PLANNING APPLICATION CONSULTATION RESPONSE

Application Number:	3/2024/0726
Proposal:	Approval of details reserved by conditions 4 (construction management/method), 5 (site access and off site works of highway mitigation), 11 (car park surface water drainage), 17 (surface water drainage) and 18 (surface water and pollution prevention) on planning permission 3/2020/0911.
Location:	Shackletons Garden Centre Clitheroe Road Chatburn BB7 4JY

Lead Local Flood Authority Position

Title: PROPOSED DRAINAGE GENERAL ARRANGEMENT SHEET 1 OF 2

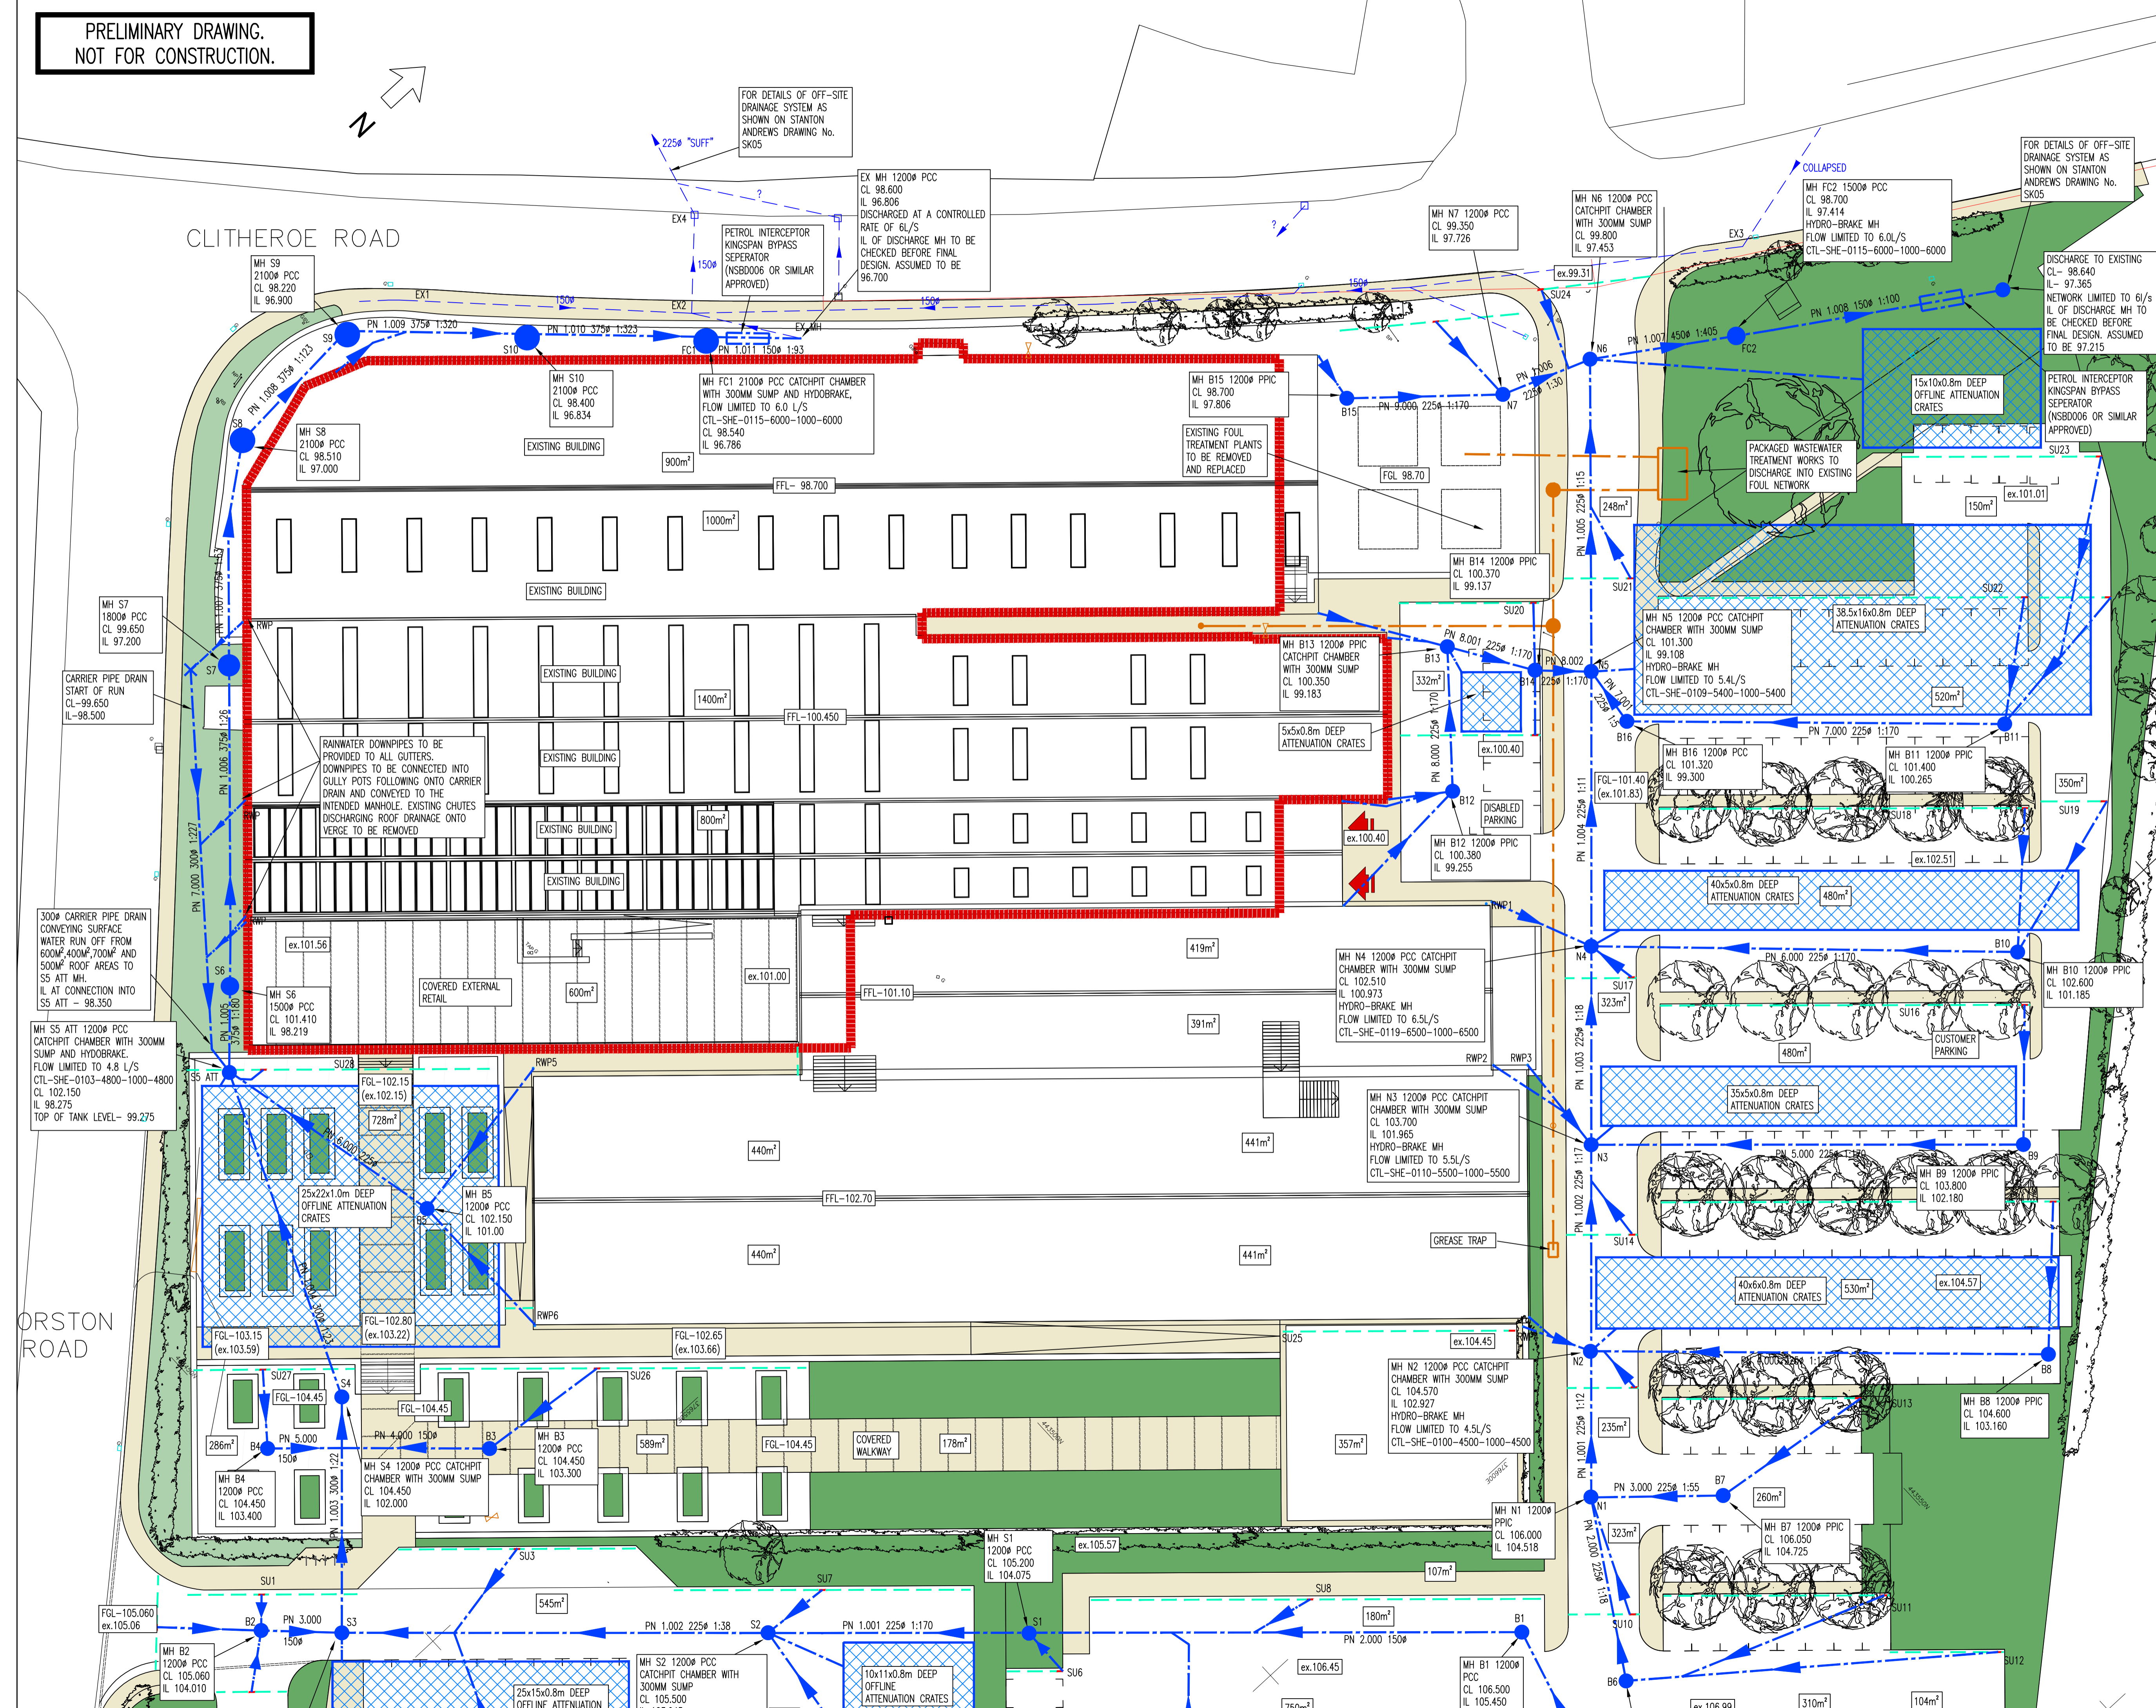
- The applicant has failed to provide evidence of Finished Floor Levels (FFL) in AOD with adjacent ground levels for all sides of each building to confirm minimum 150mm+ difference for FFL.

Title:
PROPOSED CONSTRUCTION STAGE DRAINAGE GENERAL ARRANGEMENT

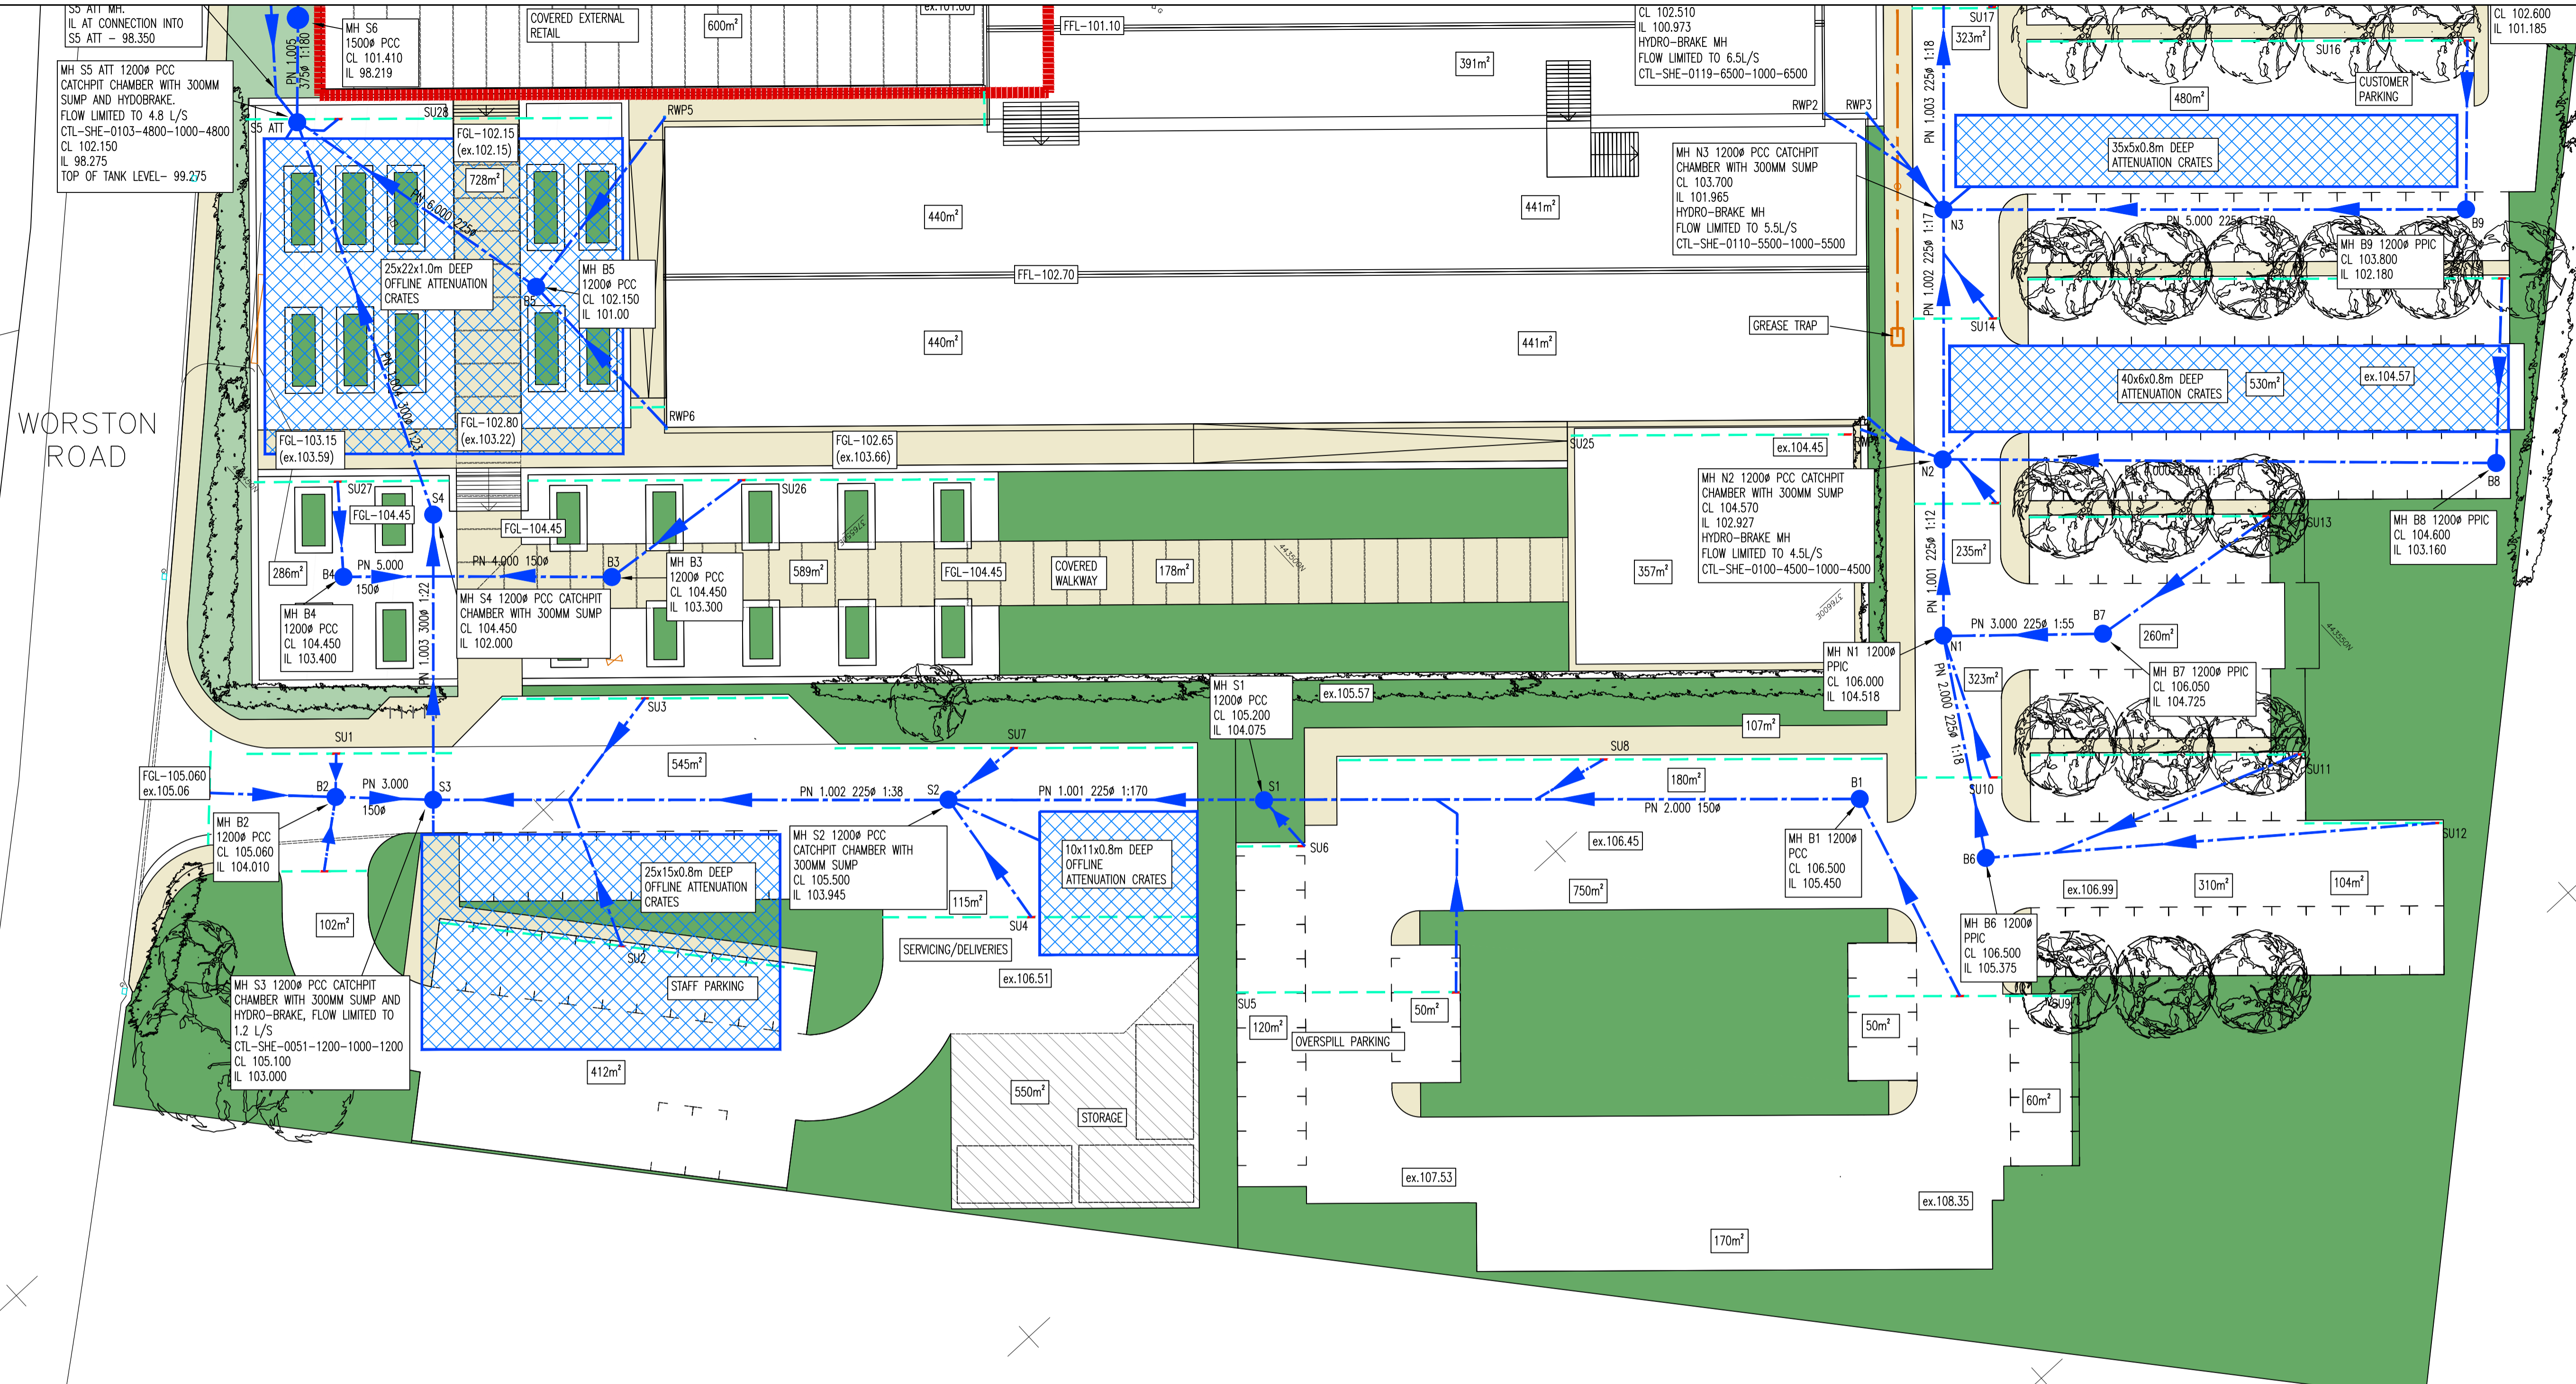
The applicant should ensure that surface water will be discharged from the temporary drainage system during the construction phase and the proposed settlement pond at a restricted rate, similar to that as the proposed discharge rate to the northern discharge location post development.

Title:
SURFACE WATER EXCEEDANCE ROUTES

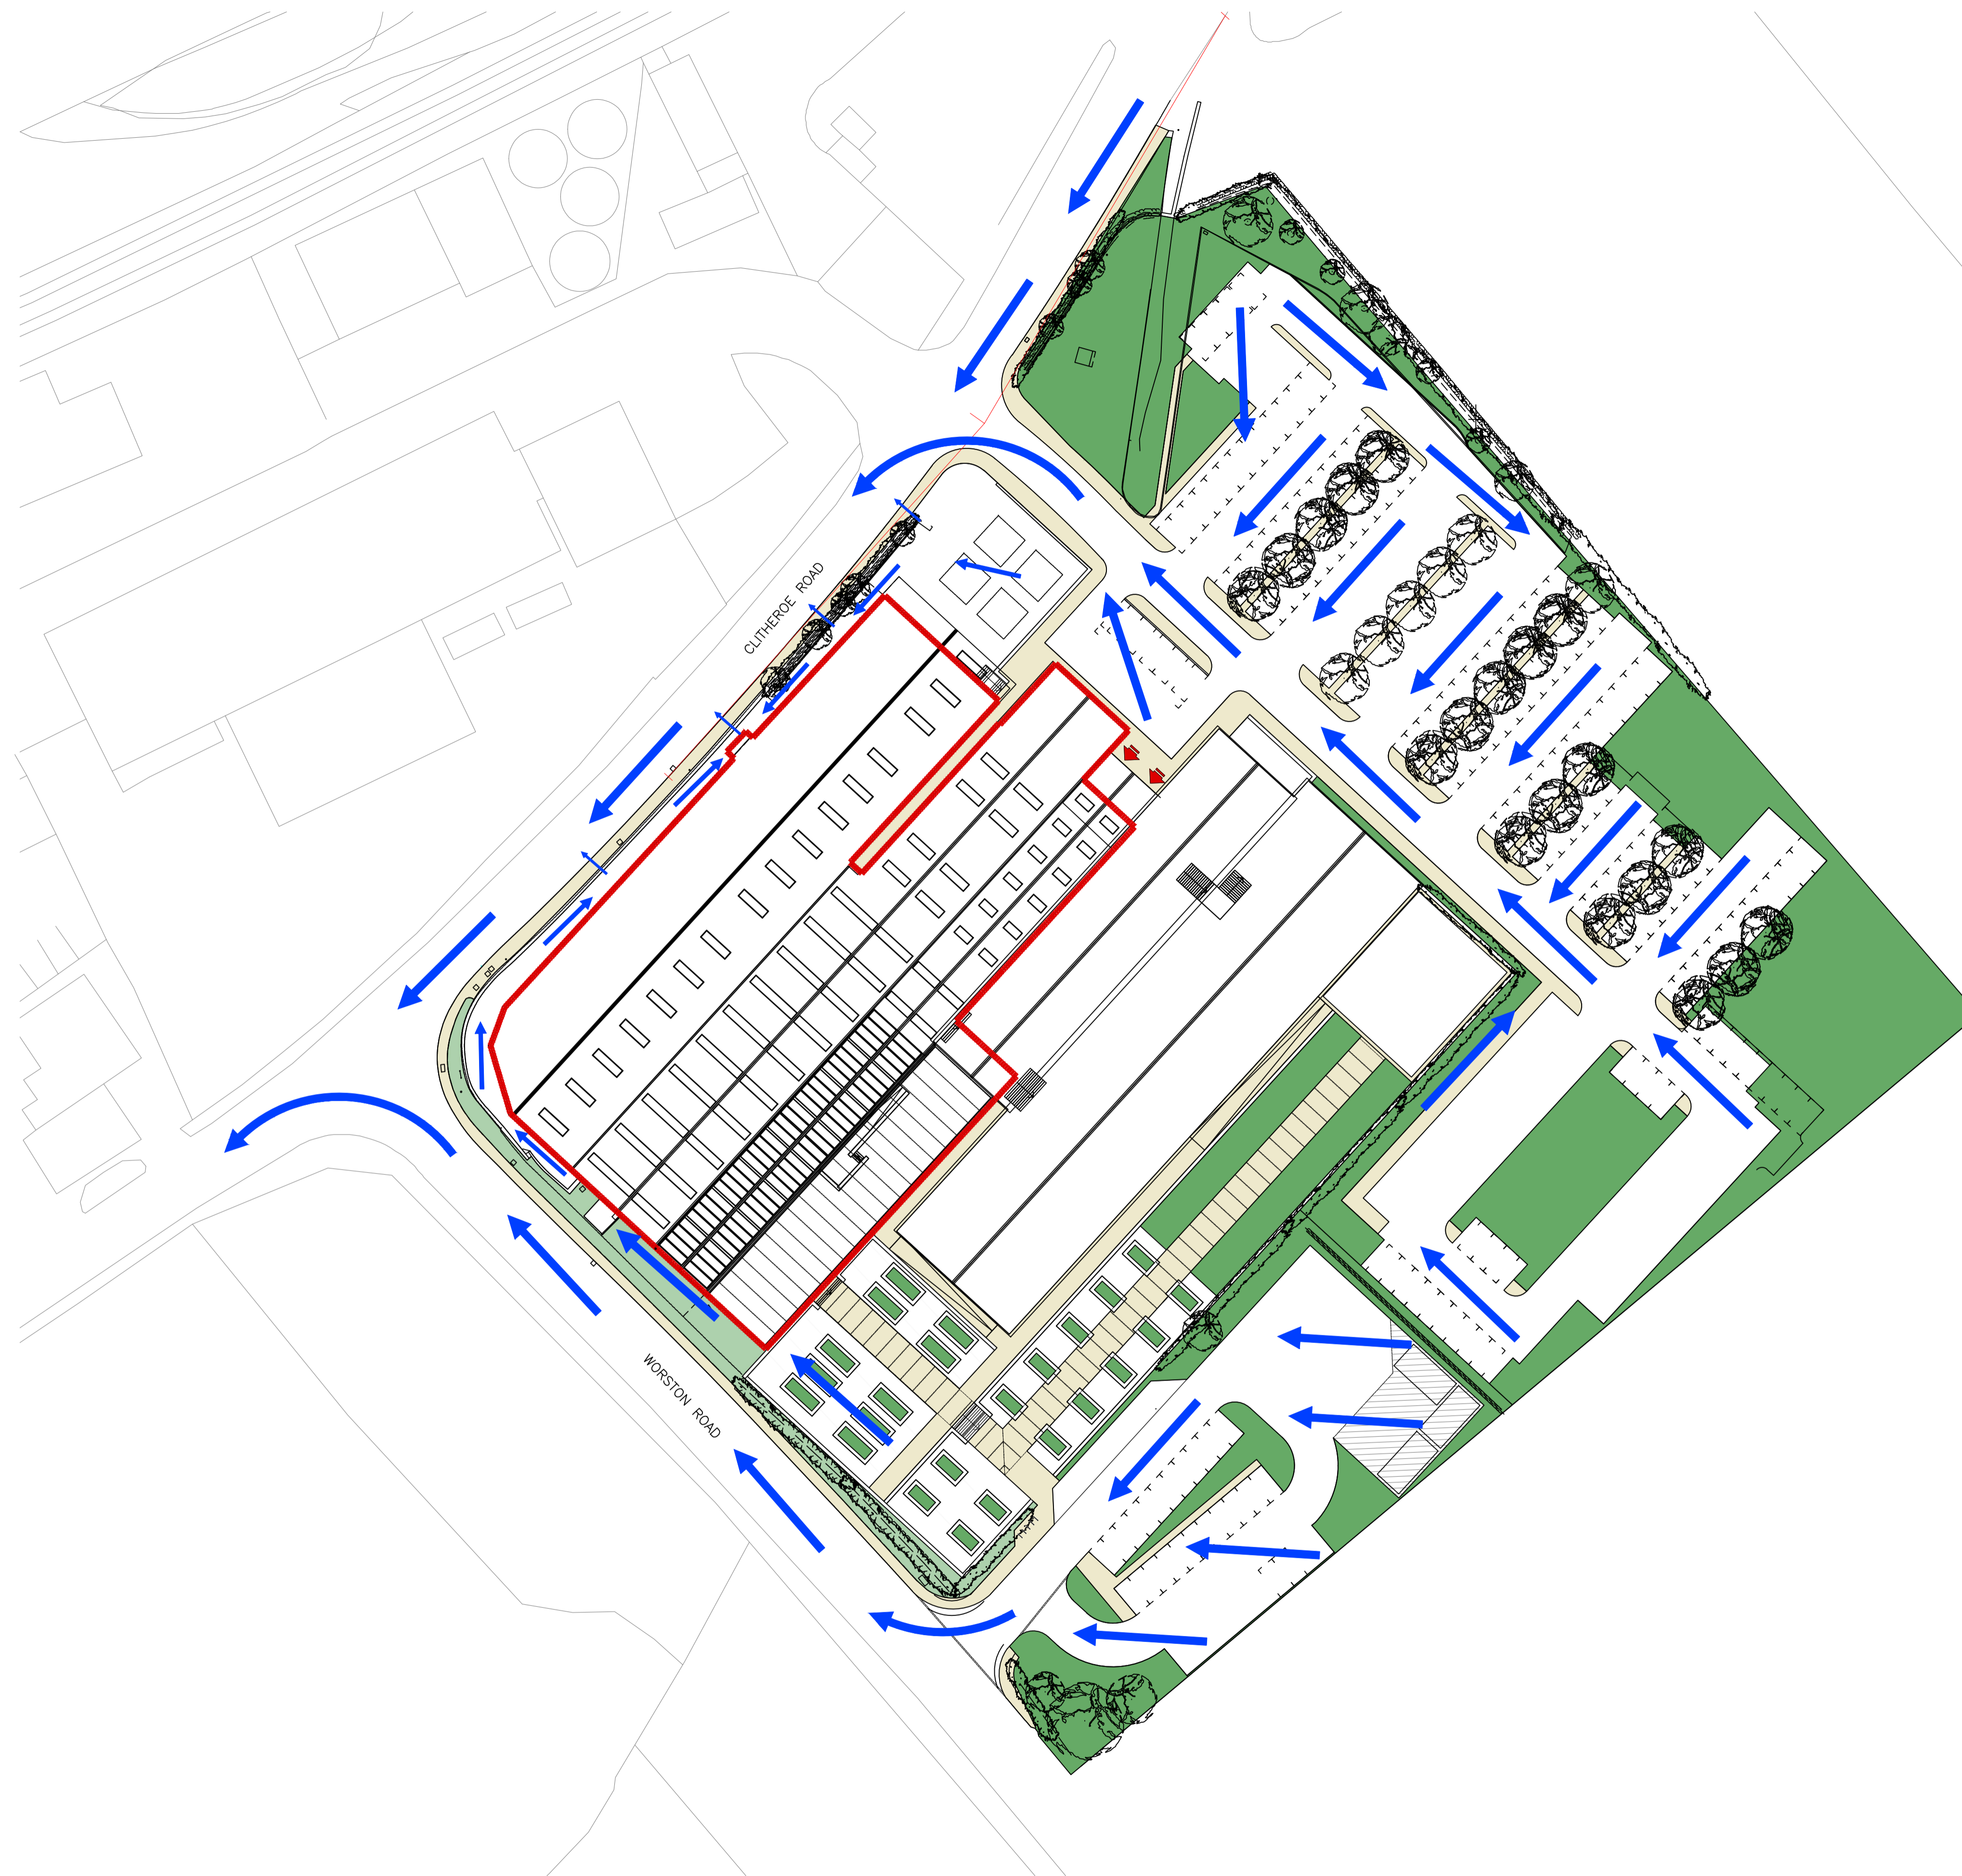
- The applicant has failed to provide evidence of flood water exceedance routes in accordance with Defra Technical Standards for Sustainable Drainage Systems.
